**KIRKLEES METROPOLITAN COUNCIL
INVESTMENT & REGENERATION SERVICE**

Reference No: 2019/62/90725/E

Site Address: Land at, Busker Lane, Scissett, Huddersfield, HD8 9JU

Description: Demolition of existing dwellings and erection of 6 apartments

Proposed Ground Floor Plan
Scale 1:100

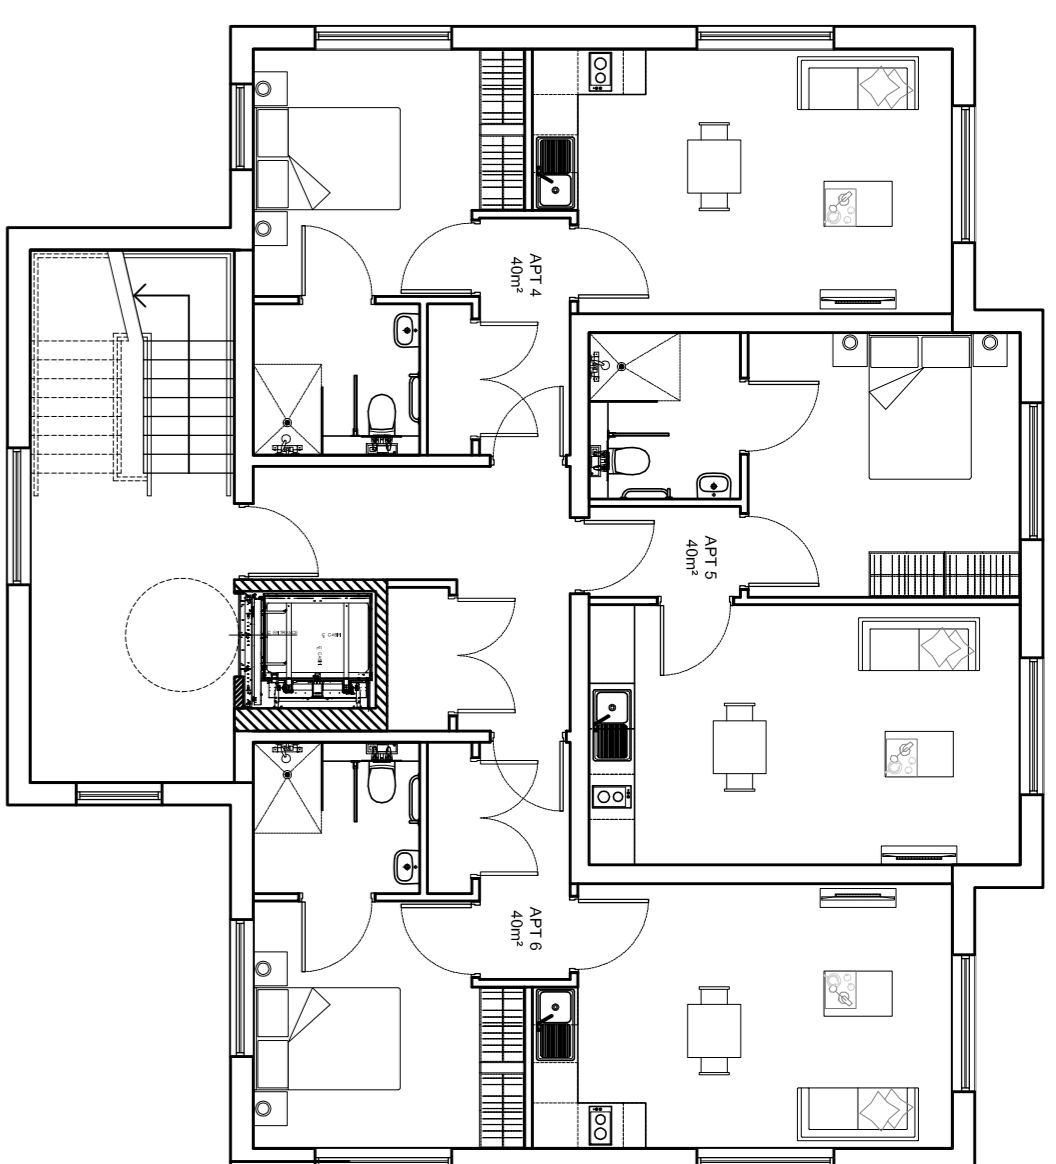
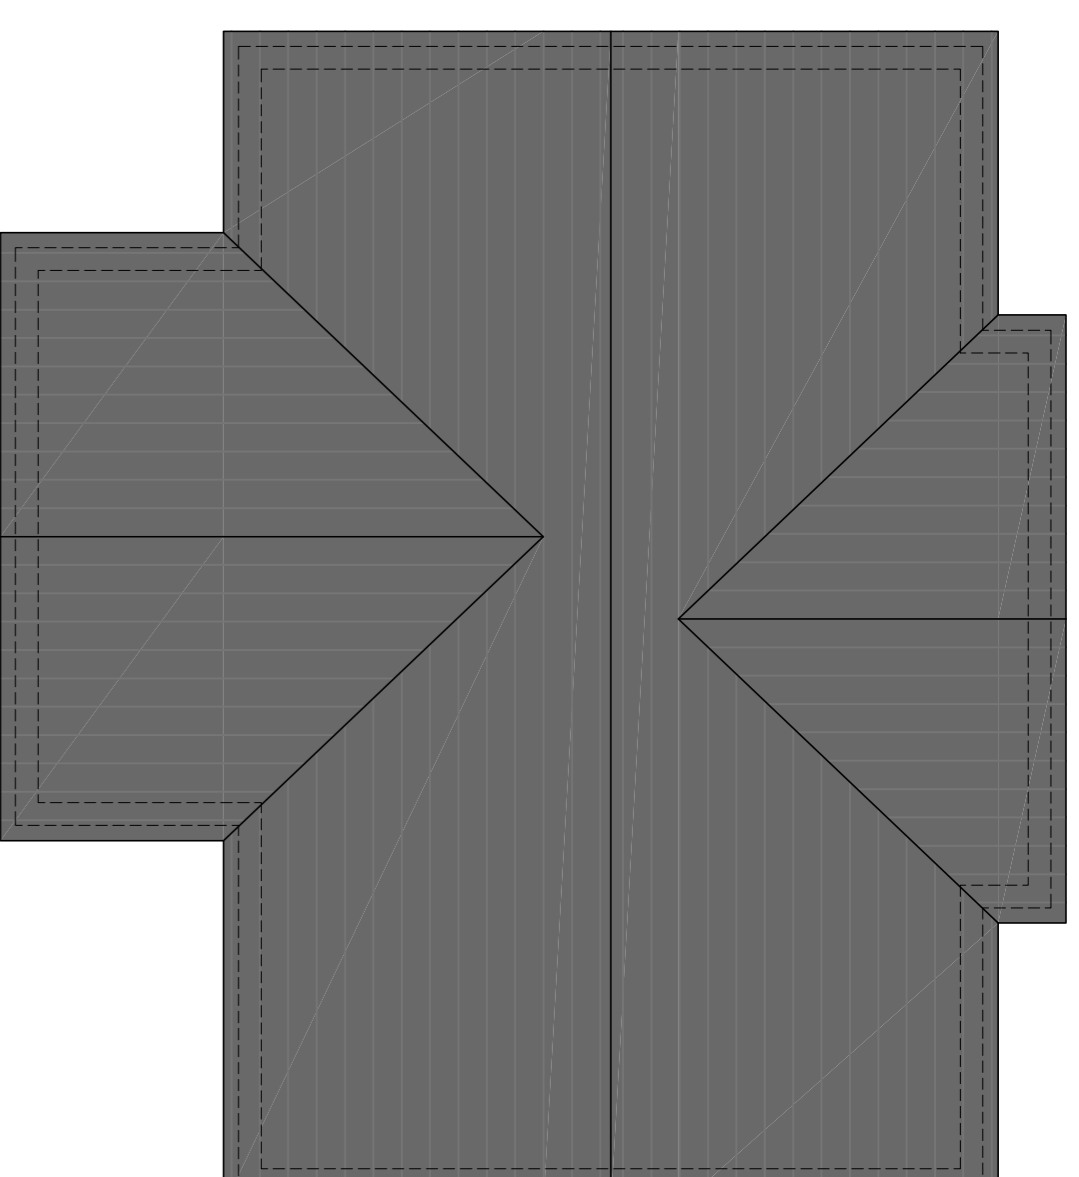
Discussions have focused on the scale of the proposed development given its Green Belt location. The scale has been reduced; a floor has been removed and the description has been amended which reduces the number of apartments from 9 to 6.

In order to create 6 new apartments, the footprint of the existing building would be extended and it is therefore considered that the new building has a materially larger footprint than the existing building. In an attempt to overcome Green Belt concerns raised during the course of the application, an amended scheme has been submitted which sees the new building being designed such that it sits lower in the street scene than the existing building. Whilst this improvement is acknowledged, it does not change the fact that the proposed building would still has a greater width on the street frontage, as well as a greater depth. As such, the building is considered as materially larger than the

Proposed Elevation 4 - Side Elevation
Scale 1:100

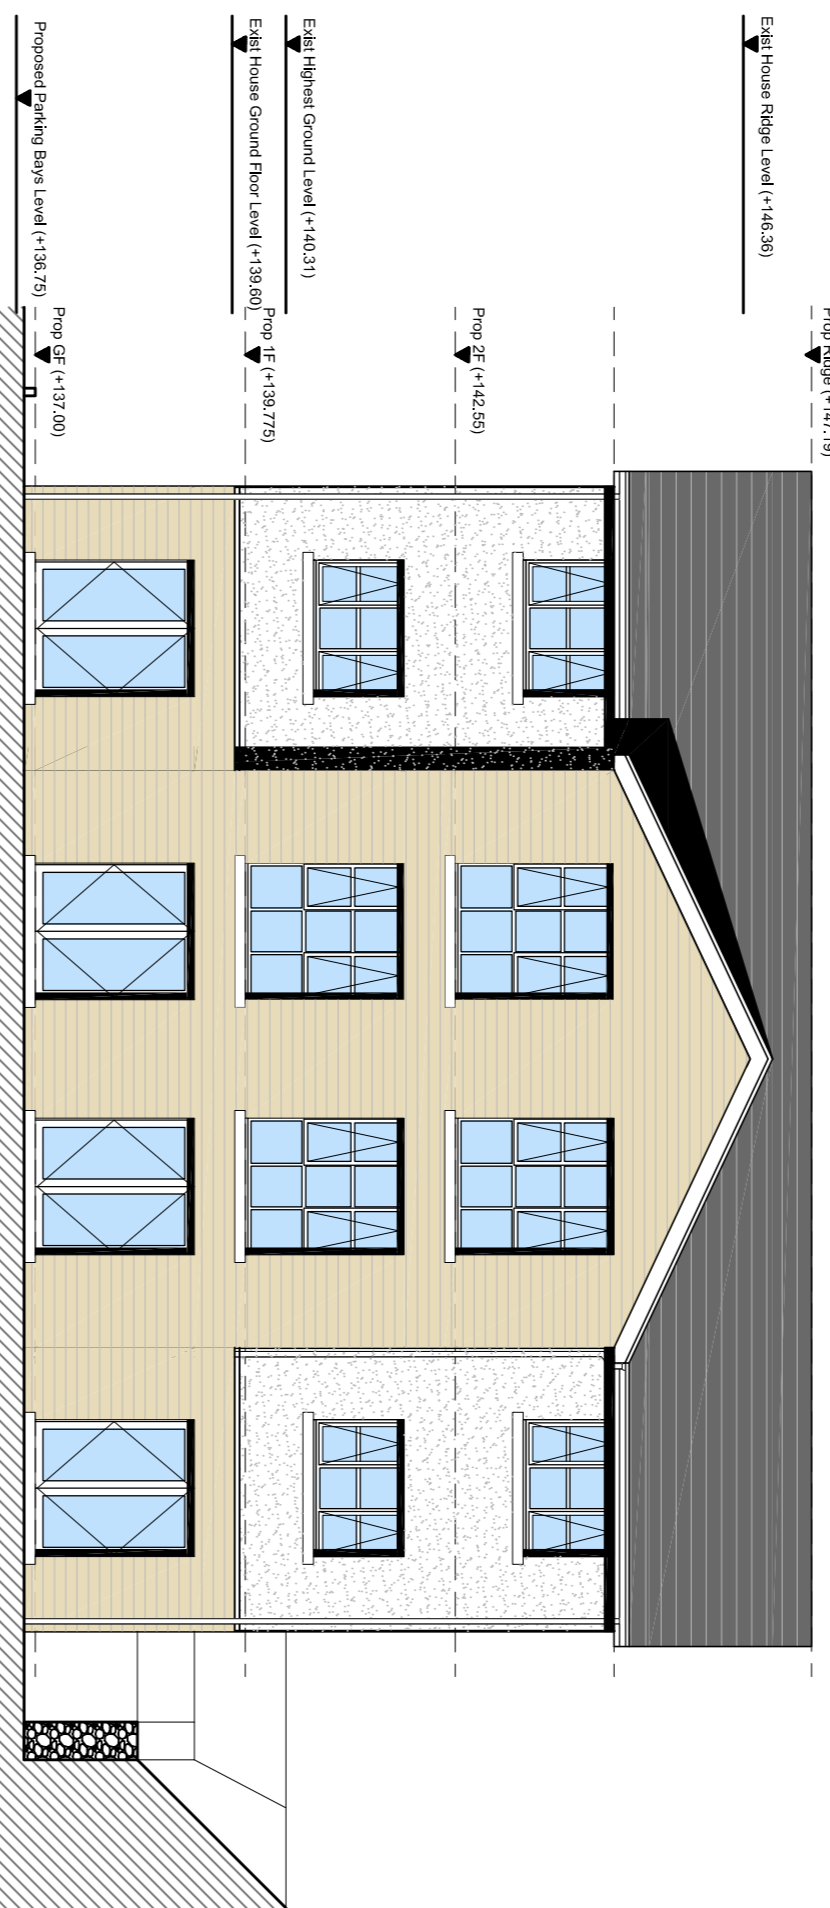
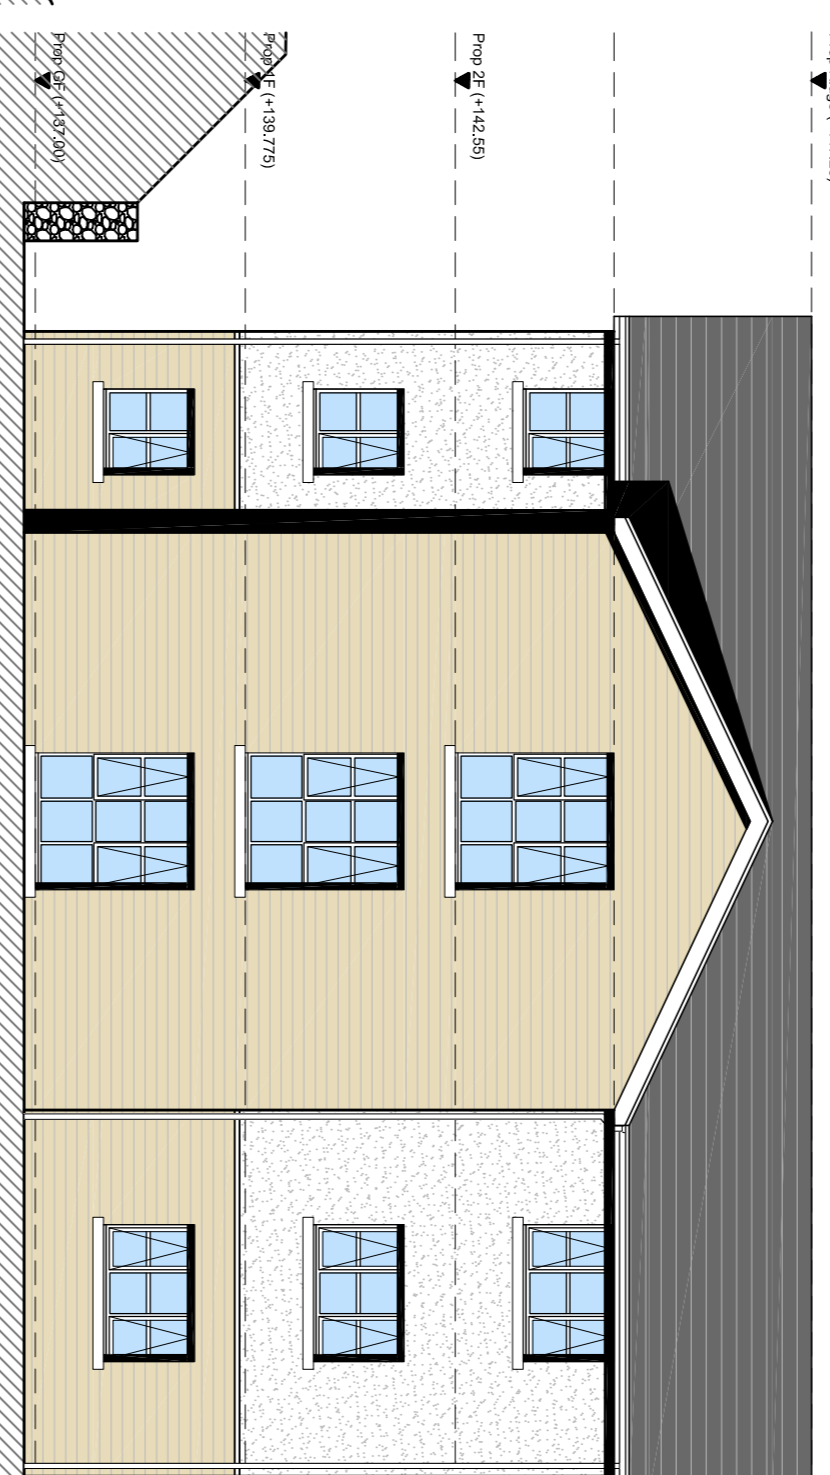
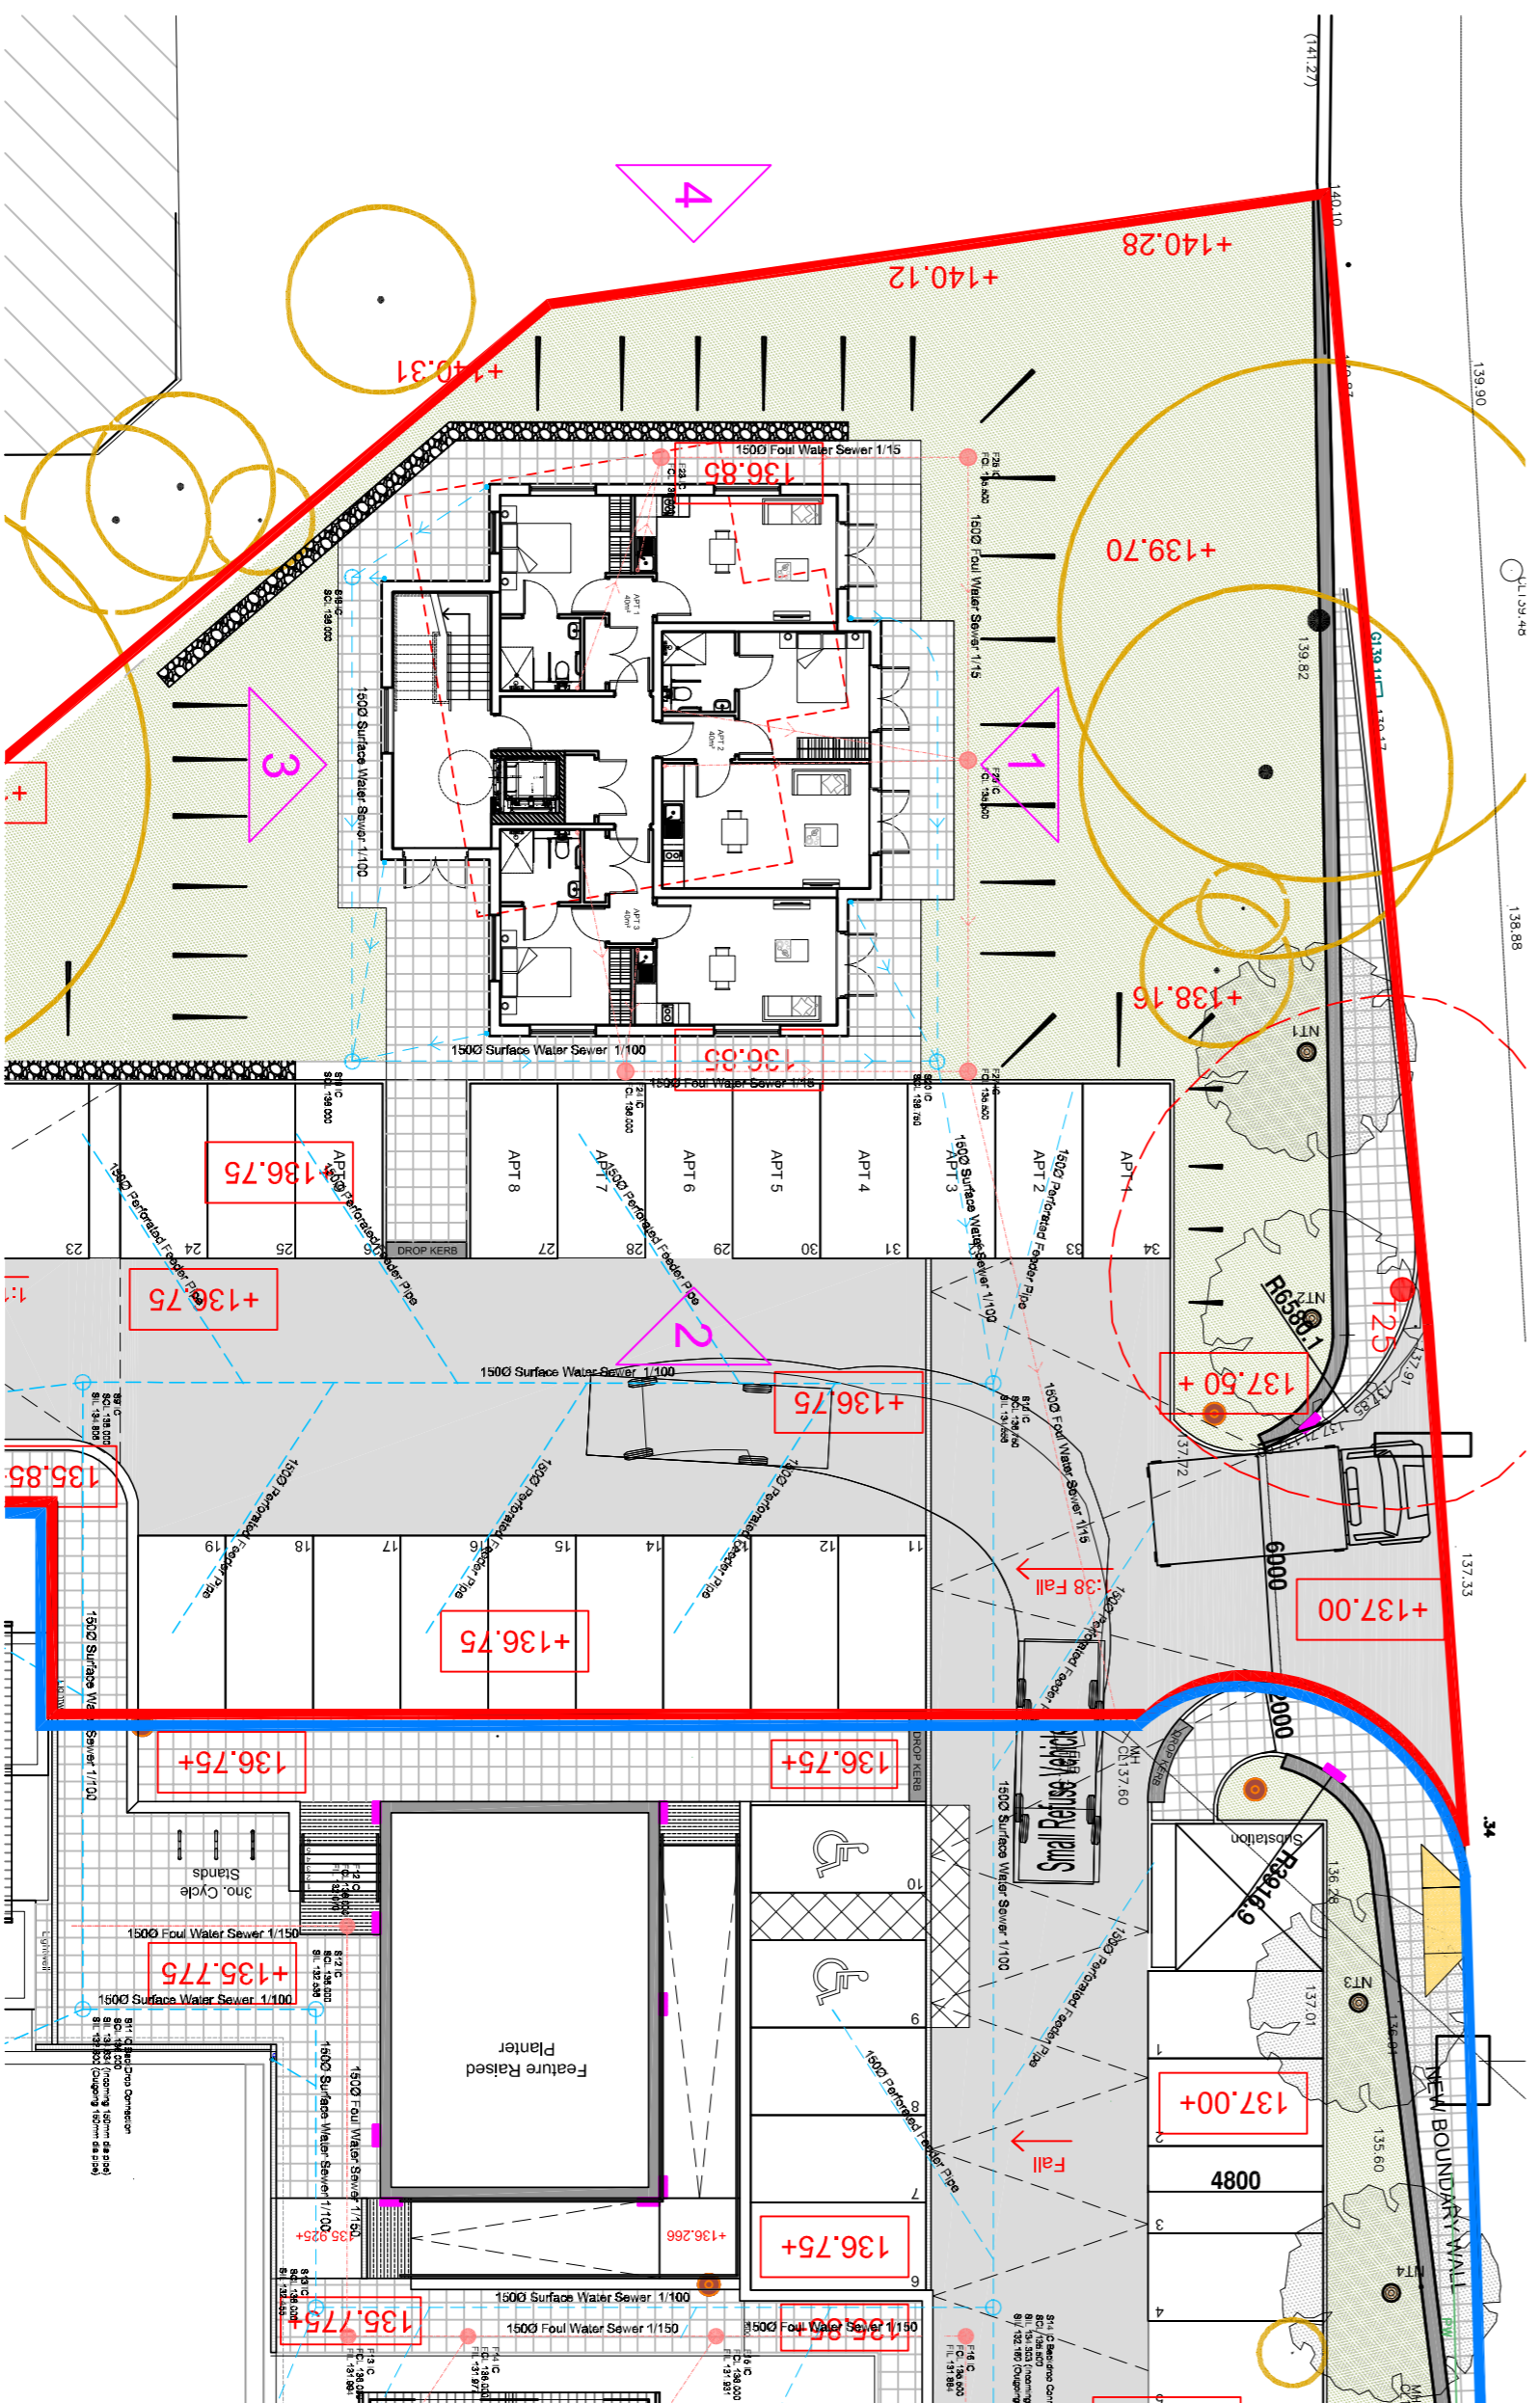
To the west of the site lies a building that is associated with the school, together with some of the school's land. It is noted that there are openings at first floor level in the side elevation, which would potentially result in overlooking to the neighbouring site. These would also serve habitable room windows and is not an existing relationship that exists. In order to ensure this conflict is avoided, it will be conditioned that these openings are obscurely glazed. As there are other openings serving these rooms, in the front and rear elevations, it is considered that the imposition of this condition would not result the creation of unacceptable living conditions for the occupants.

5. The development shall not be occupied until the first floor windows in the western side elevation of the building hereby approved have been obscure glazed (minimum obscurity level 5). The obscure glazing shall thereafter be retained.
